Rezoning Transportation Analysis

Petition Number: #2022-045

Revision Log:

Date	Description
08-11-2022	First Review (WB)
09-21-2022	Second Review (JC)
10-26-2022	Third Review (DR)

RZ-2

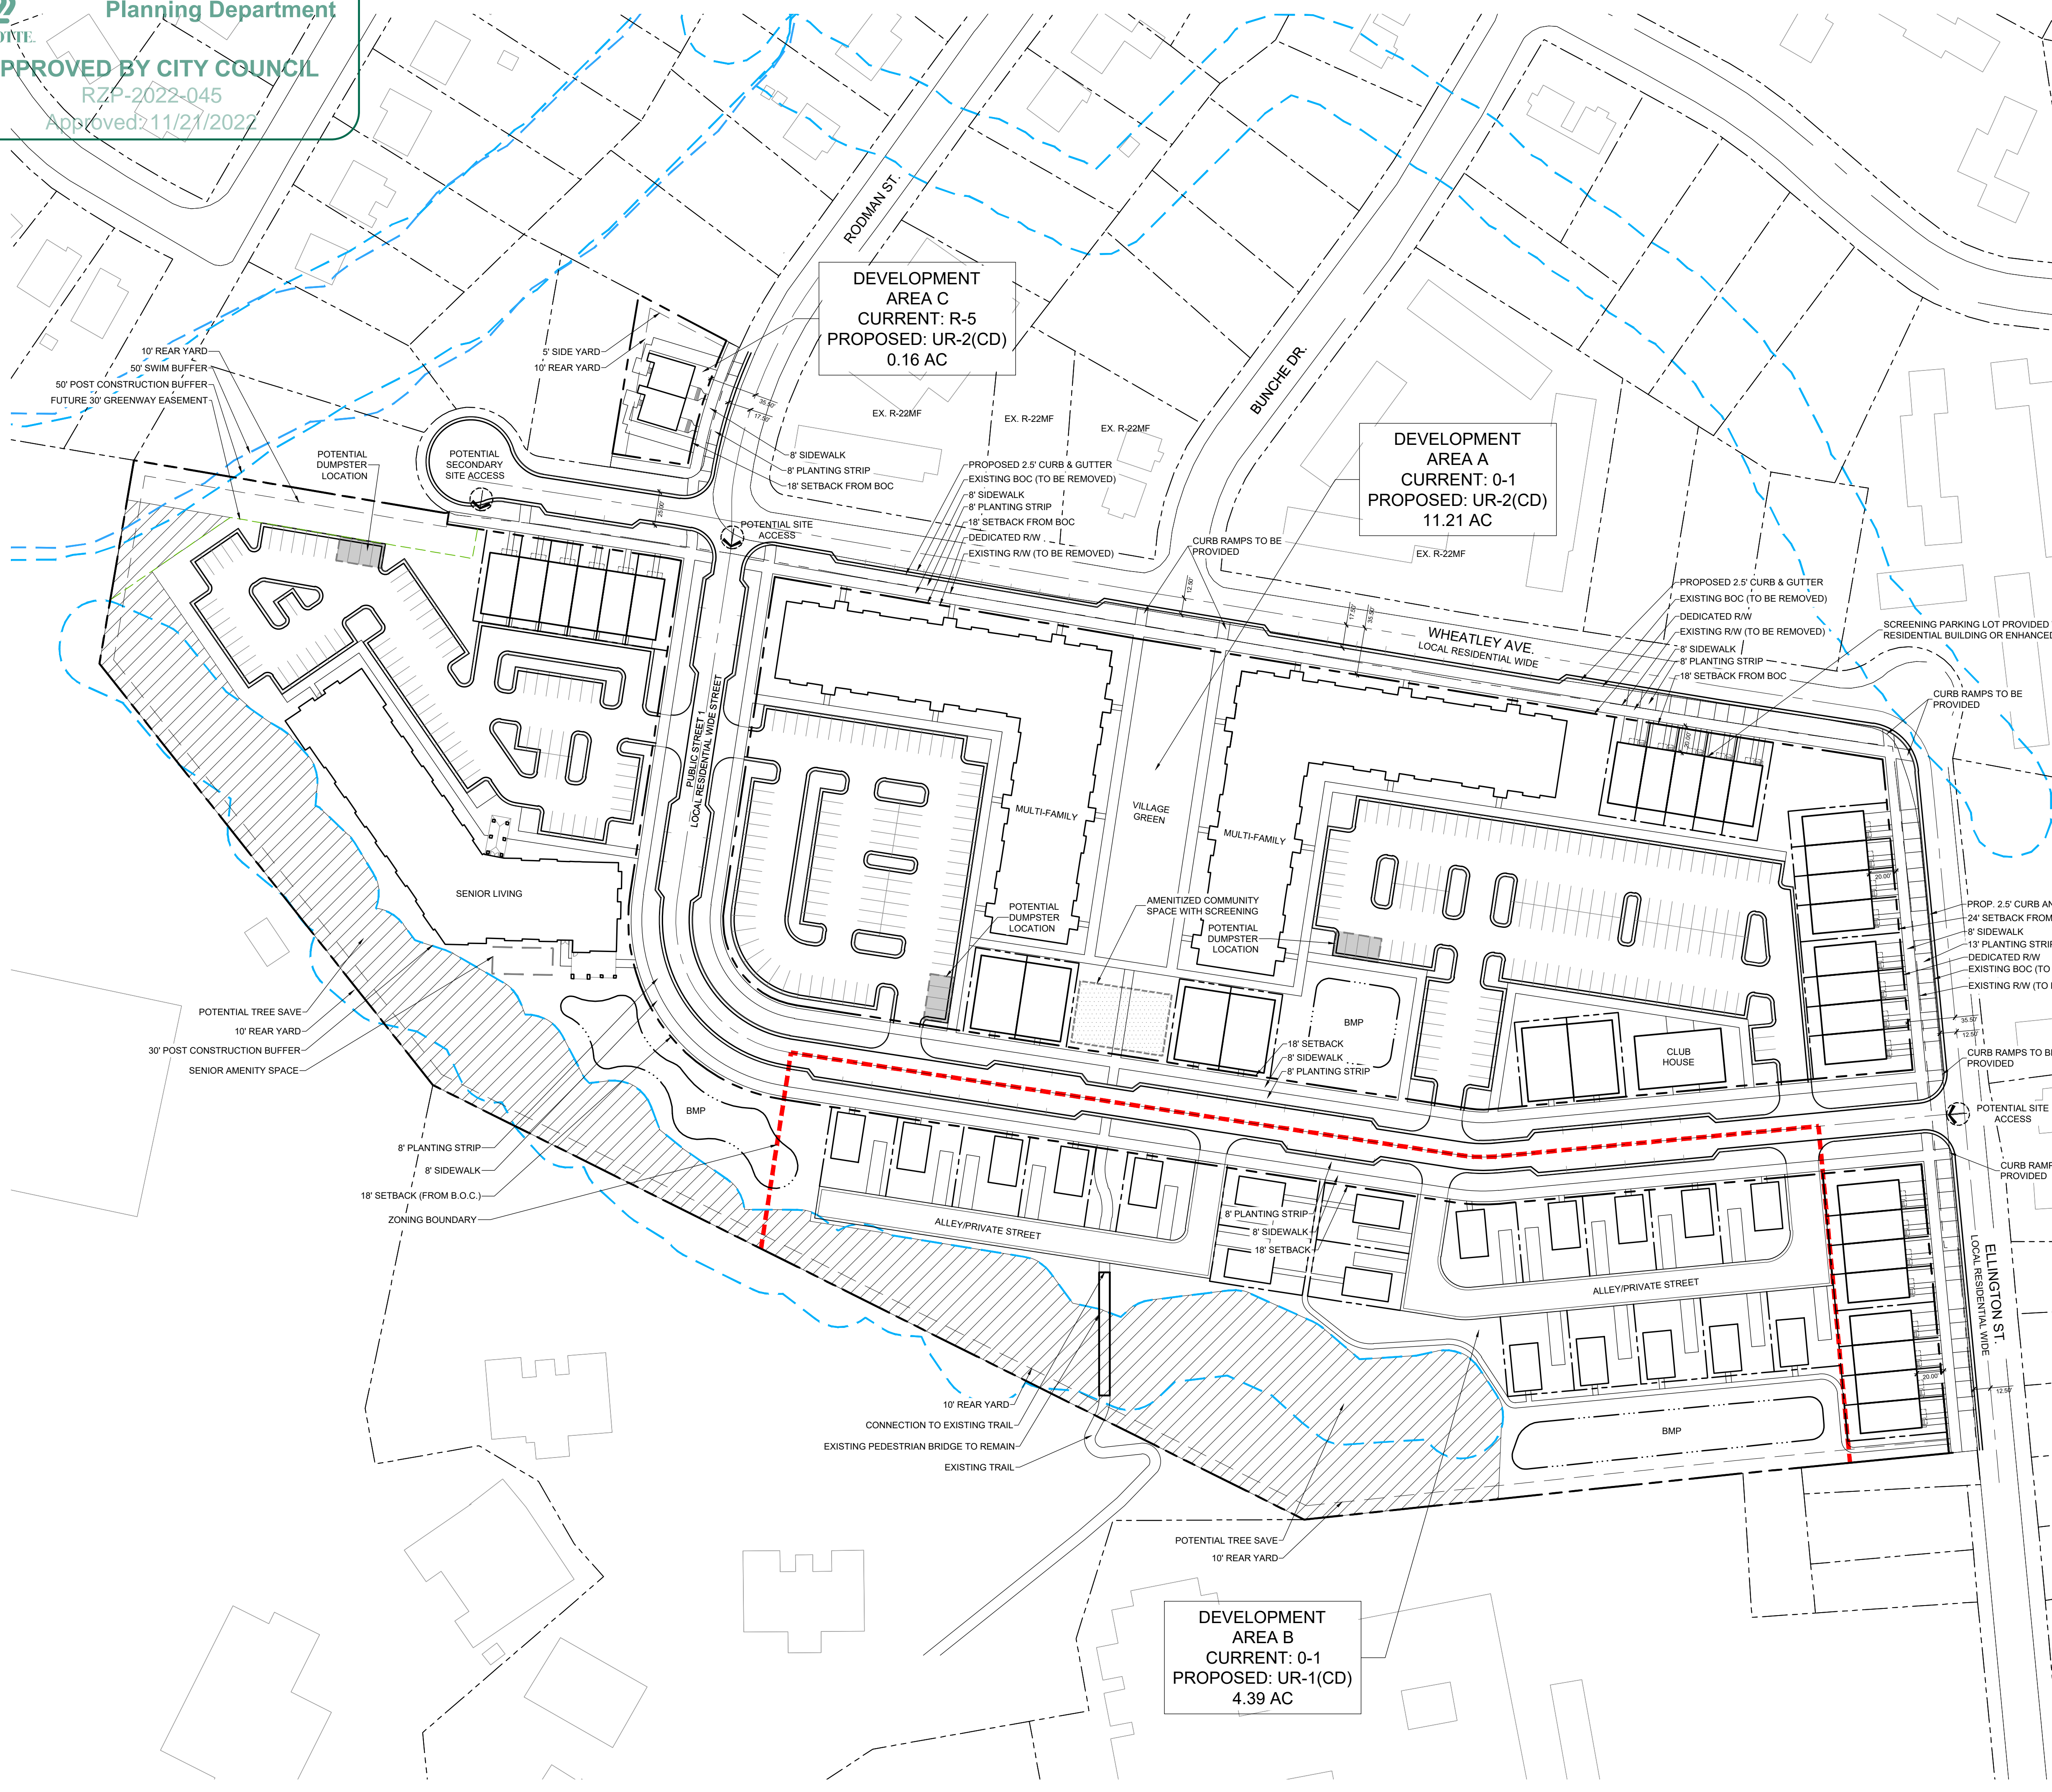
a. **Wheatley Avenue:** The curb and gutter needs to be constructed 17.5-ft from the road centerline. **Comment Update 10-26-22:** Back of curb for U-03C section to be located 12.5-ft from road centerline, not 11.5-ft as dimensioned on site plan.

b. **Ellington Street:** ~~The curb and gutter needs to be constructed 20.5-ft from the road centerline.~~ **Comment Update 09-21-22:** back of C&G to be constructed at 17.5-ft from road centerline except where driveways require utilization of CLDSM U-03C, where back of curb is to be located at 12.5-ft from road centerline. **Comment Update 10-26-22:** Back of curb for U-03C section to be located 12.5-ft from road centerline, not 11.5-ft as dimensioned on site plan.

Label and dimension the curb and gutter from the centerline for each road on the site plan.

Comment Update 09-21-22: Label and dimension the curb and gutter from the centerline along Ellington St. where U-03C to be used. **Comment Update 10-26-22:** Back of curb to be located 12.5-ft from road centerline, not 11.5-ft as dimensioned on site plan.

Resolved: New Comment 09-21-22: Dimension typical driveway length for residential driveways to remain along Wheatley and Ellington. Minimum 20' between proposed right-of-way and townhome structures.
